Your Ref :
Our Ref : BN/24/13/NMA

Application for a non material amendment following a grant of planning permission BN/14/10/ for window changes to west elevation, additional window above porch, reduced size window (top left), addition of new roof per plan and window on west elevation.

Watermead, Yapton Road, Barnham,

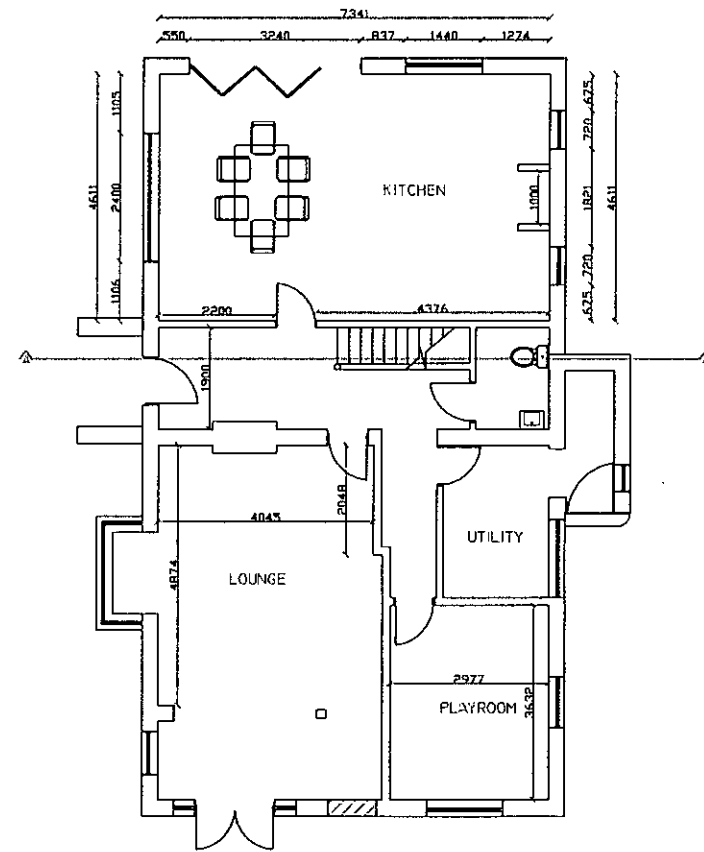
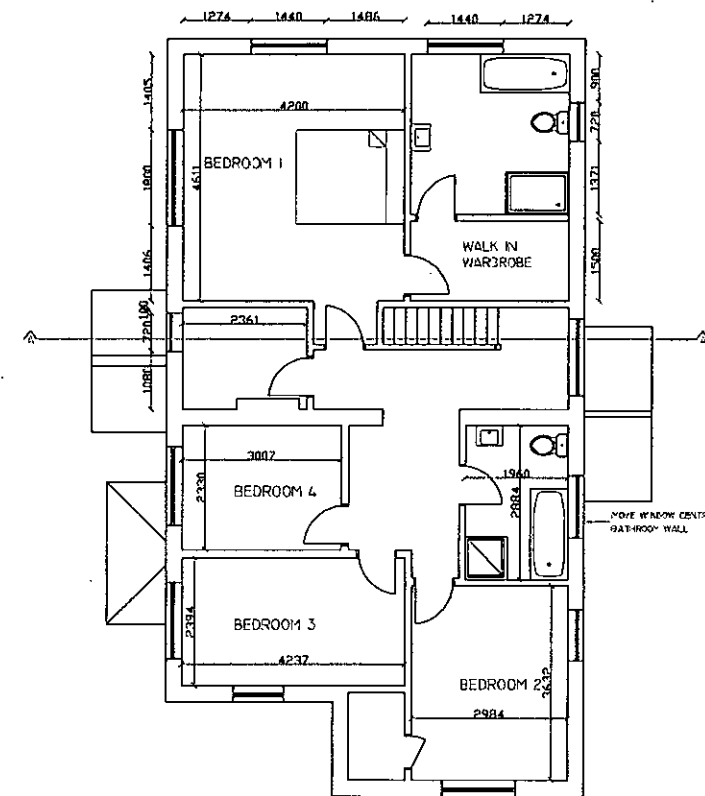
The installation of a hipped roof above single storey element on west side elevation.
Reduced size window at first floor level serving bedroom on west side elevation.
Additional window at first floor level above porch on west side elevation.
Removal of window at first floor level on east side elevation.
Replace flat roof with hipped roof over lounge doors on south side elevation.

The above changes can be accepted as a non-material amendment. The submitted Floor Plan Drg No WAT-04-10 Rev C and Elevations Drg No WAT-02-10 Rev C now become the approved plans for planning application BN/14/10.
